Re: Response to Submissions - MOD 11 Karuah (East) Pit Consolidation Project - MP09_0175-Mod-11 and MOD 2 Karuah (Hard Rock) Pit Consolidation Project - DA265-10-2004-Mod 2

Hunter Quarries (HQPL) has engaged EMM Consulting Pty Limited (EMM) to undertake a review of the advice received from the Water Group within the NSW Department of Climate Change, Energy, the Environment and Water (NSW DCCEEW – Water Group) on 19 June 2026 in relation to the concurrent Modification Applications for the Karuah Pit Consolidation Project as follows:

Karuah Pit Consolidation Project
Karuah East Quarry MOD11 (MP09_0175)
Karuah Hard Rock Quarry MOD2 (DA265-10-2004)
Response to Submissions

Figure 16: Groundwater Monitoring Bore Network

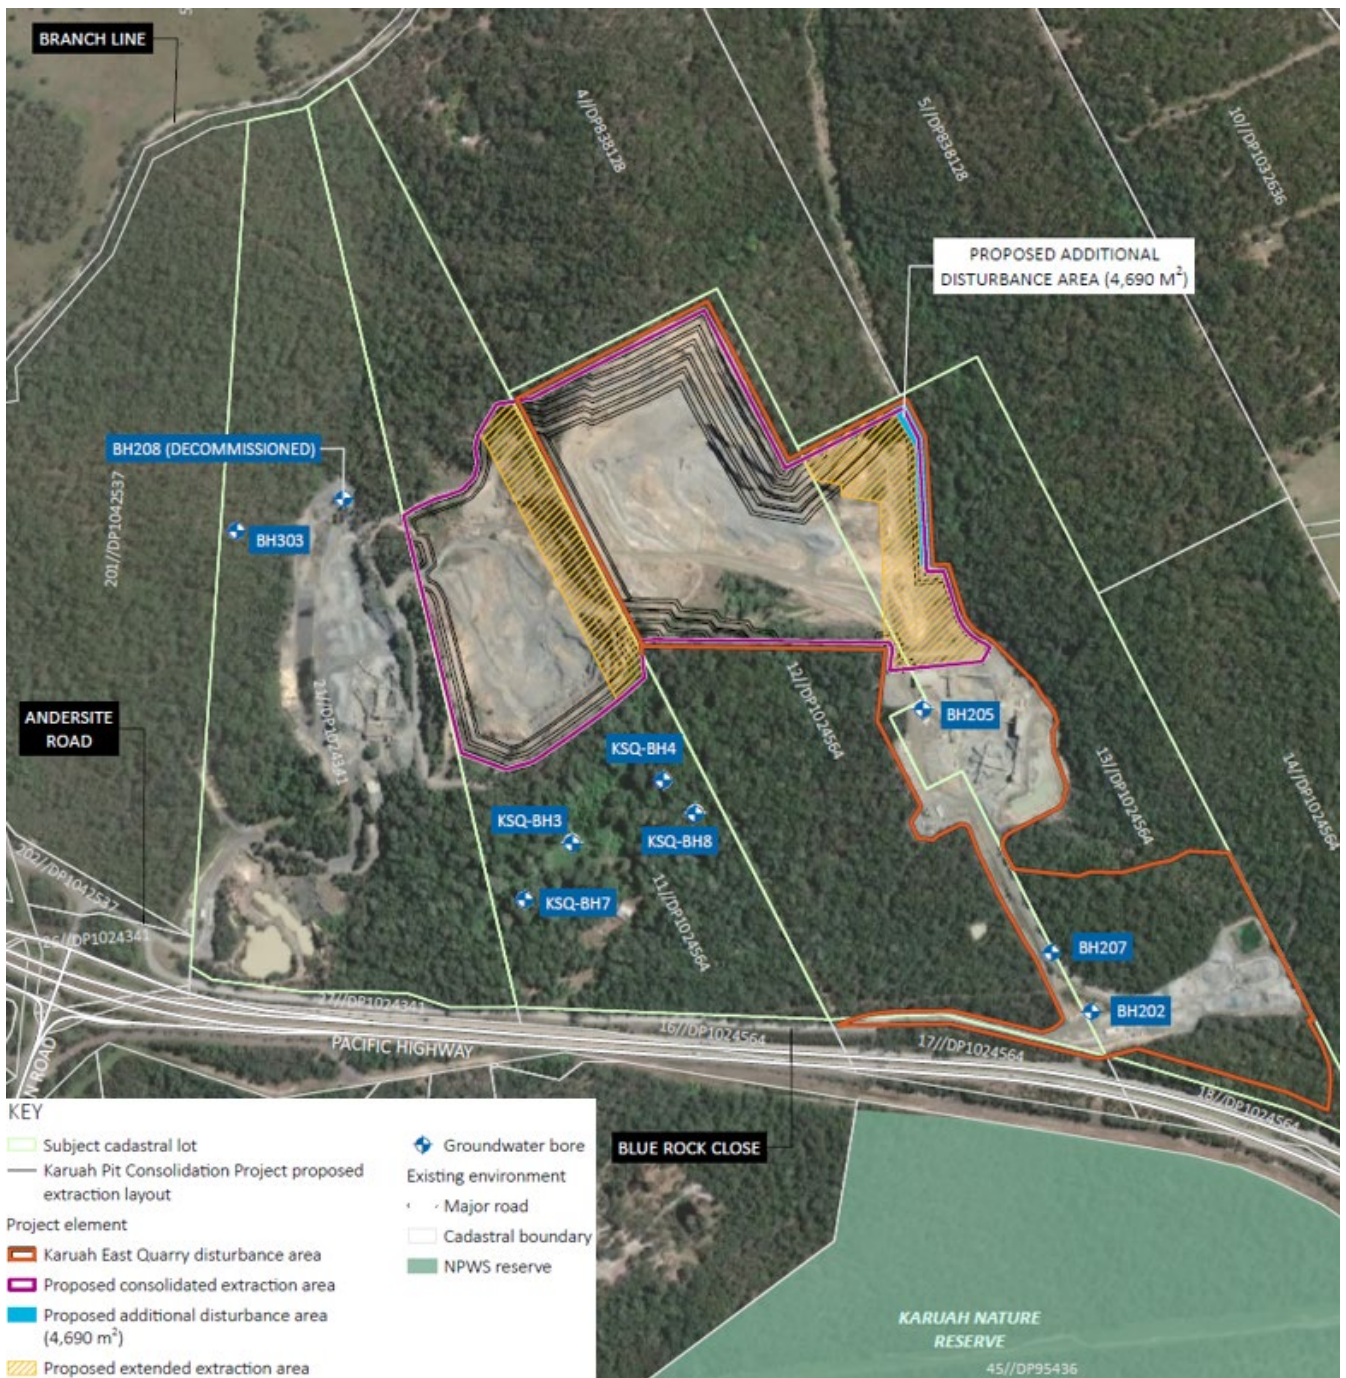
No.	DCCEEW – Water Group comment	Proponent response
1.1	The Department of Planning, Housing and Infrastructure (DPHI) should request that the proponent install two additional groundwater monitoring bores to the north and north-west of the proposed final quarry footprint, to ensure groundwater levels below the proposed floor level of RL 45 mAHD are adequately characterised and monitored.	As requested, two (2) additional groundwater monitoring bores will be installed north and north-east of the proposed Consolidated Extraction Area (CEA). The proposed locations of the bores are shown in Figure 1. The proposed bore on Lot 11 DP1024564 will replace existing bore BH208 which has been decommissioned due on-going maintenance issues associated with the location's steep topography. The proposed bore on Lot 5 DP838128 will address the monitoring gap north-east of the proposed additional disturbance area to the north-east of the site. Both bores will be constructed to a depth greater than the approved KEQ floor level of RL 45 mAHD. The proponent commits to the installation of the two (2) bores on the following basis: a) A new KEQ Groundwater Management Plan will be submitted to DPHI within 6 months of determination of the concurrent Modification Applications (Item 1.2). b) Installation to be completed within 18 months of determination of the concurrent Modification Applications. c) No extraction to occur within the 'Proposed Extended Extraction Area' within the CEA on Lot 13 DP1024564 as shown in Figure 2 until: (i) the KEQ Groundwater Management Plan (refer to Item 1.2 below) has been approved by DPHI (ii) both new monitoring bores have been installed. Until items (a) and (b) have been completed, extraction will be limited to the currently approved extraction areas and the 'Proposed Highwall Extraction Area' within the CEA on Lot 11 and Lot 12 DP1024564 as shown in Figure 2. <i>Note: that the plan provided in Figure 2 is reproduced from Figure 4 of both Section 4.55(2) Modification Reports for the KHRQ and KEQ.</i> Extraction of the 'Proposed Highwall Extraction Area' (as shown in Figure 2) between the two well established quarry pits will not interact with groundwater. This assessment is supported by the absence of groundwater inflows at the existing quarry pits (refer to Section 5 of the Groundwater Assessment that accompanied each Section 4.55[2] Modification Report [Appendix K of both documents]) and depth to groundwater measured using the existing monitoring network.
